CITY OF ALBUQUERQUE

**Re: AMERICA'S PASSTIME, Grading and Drainage Plan
Engineer's Stamp Date 11/30/2012 (C18/D035)**

Based upon the information provided in your submittal received 11/30/2012, the grading and drainage plan is approved for Building Permit and SO-19 Permit based on the following comment:

AMERICA'S PASTTIME
GRADING & DRAINAGE PLAN

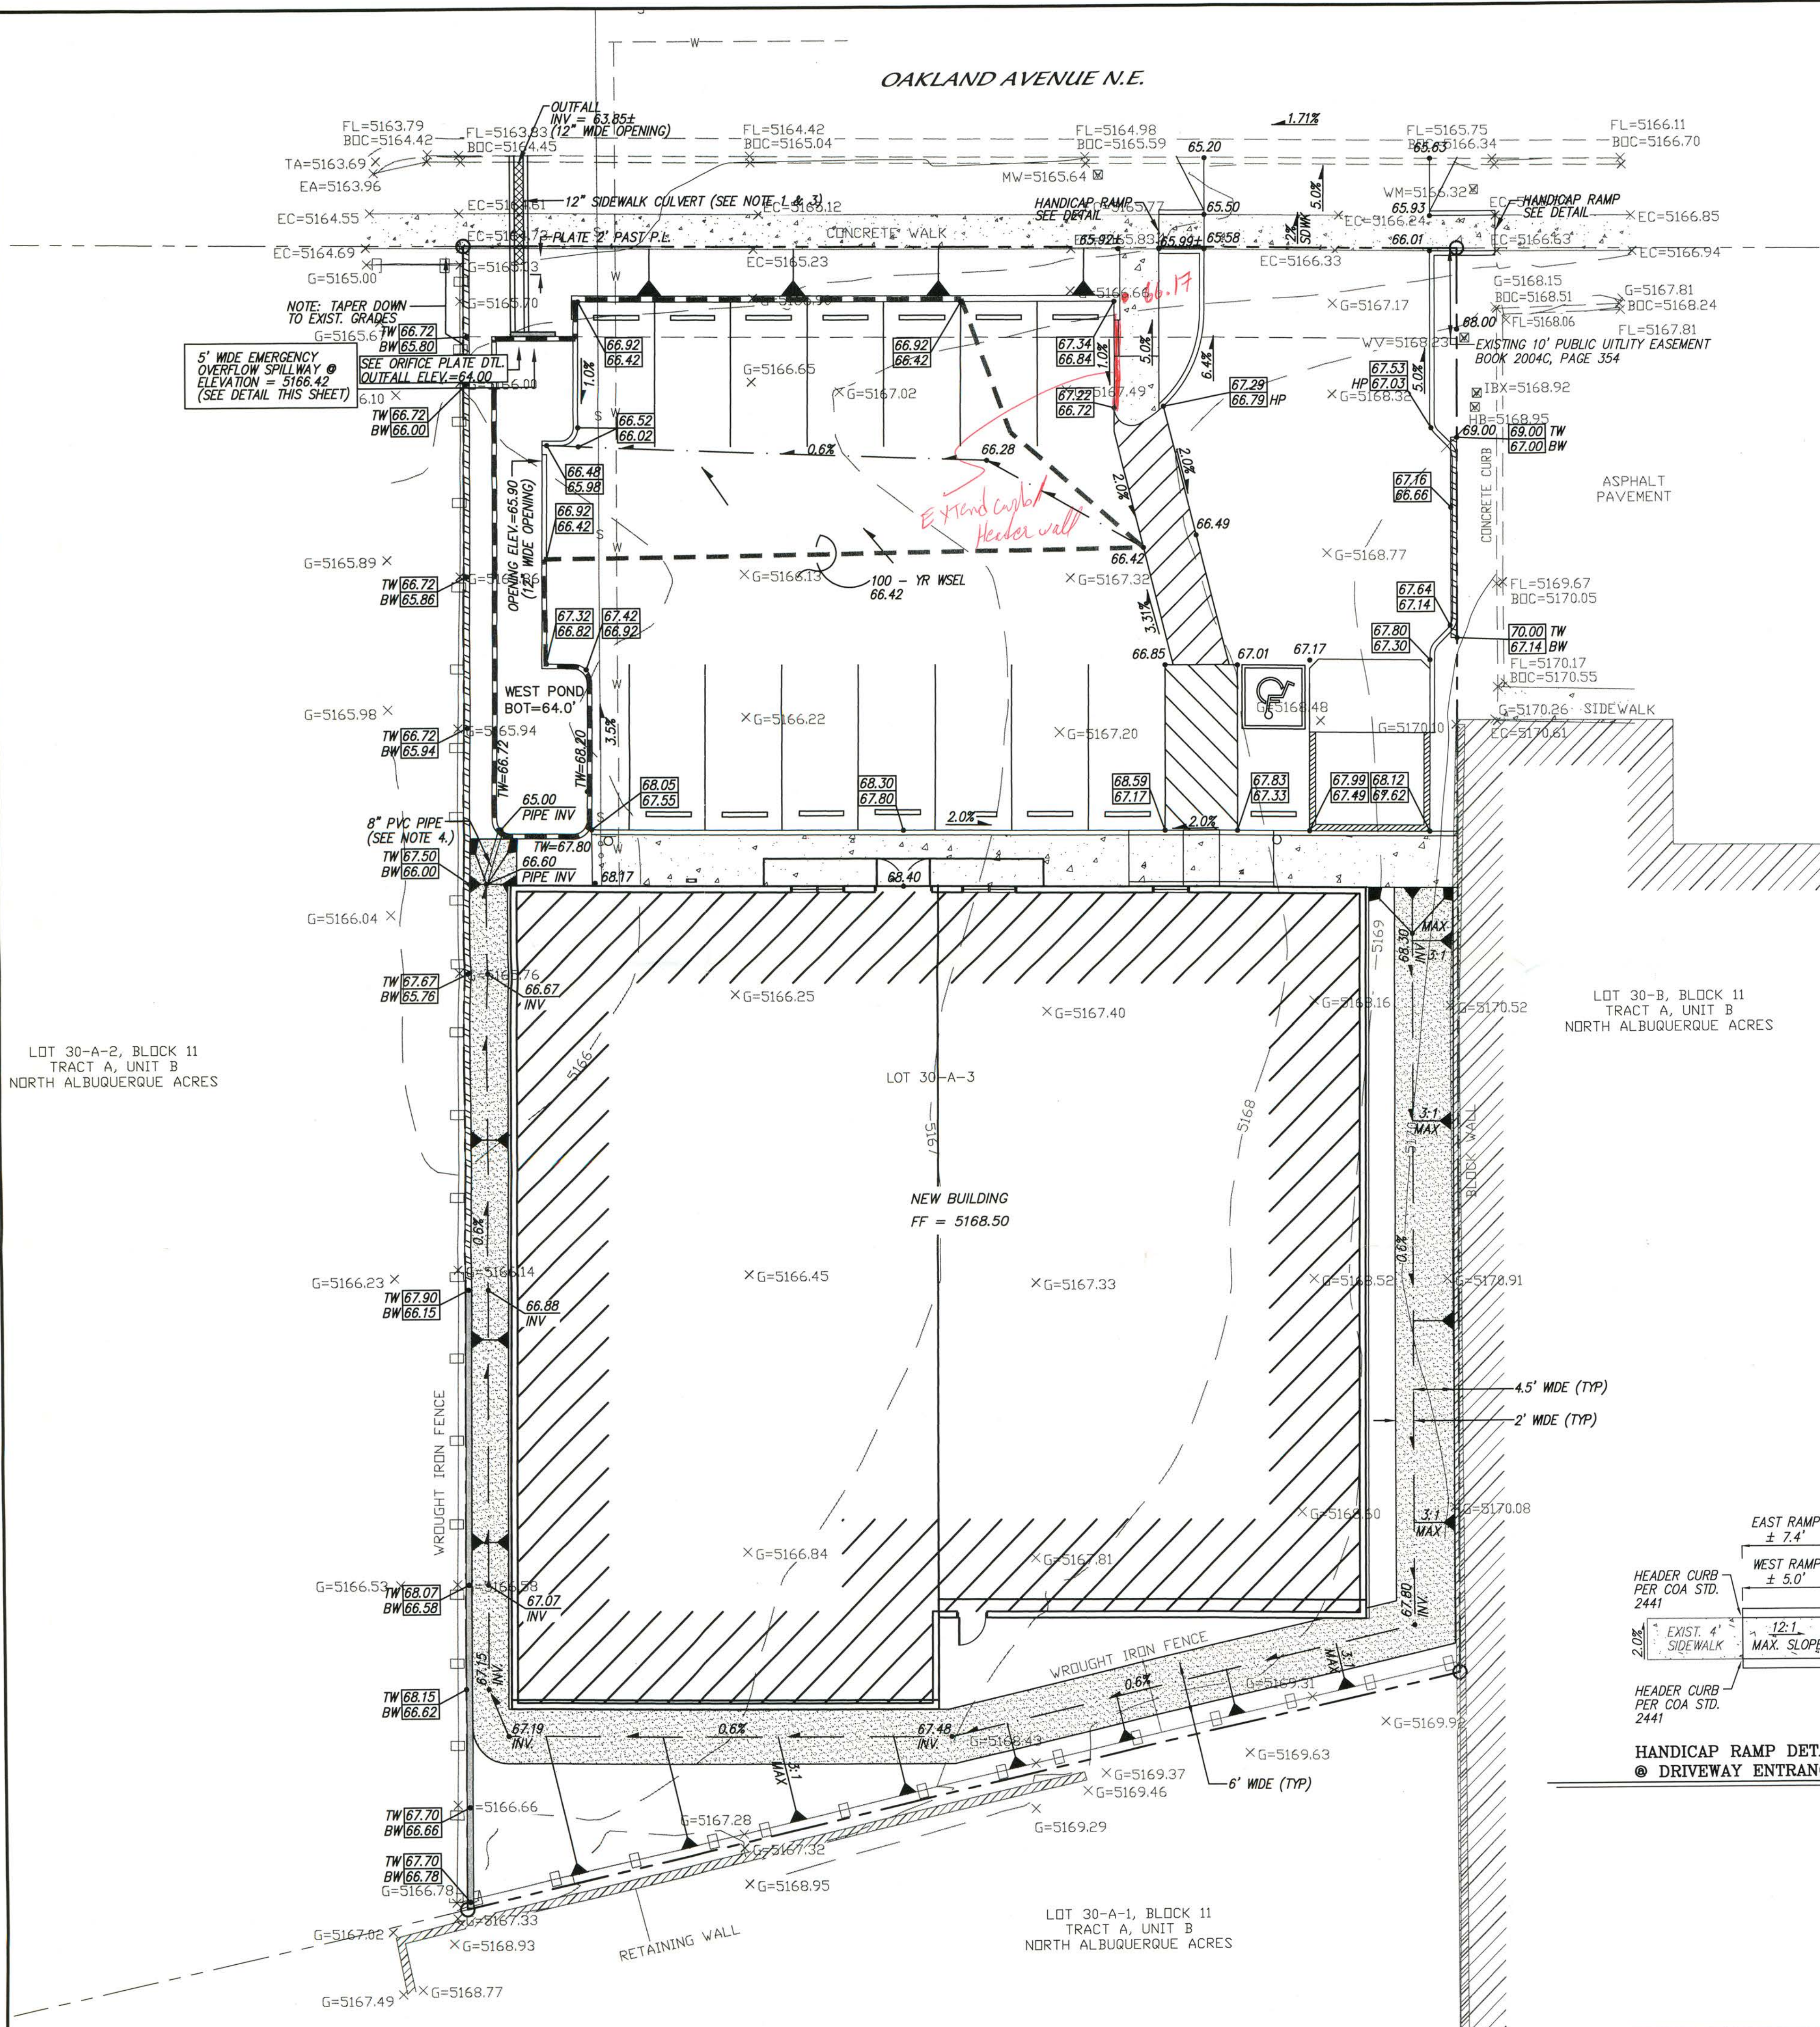
- Provide spot elevation and extend the curb along the parking space as shown on the attached sketch.
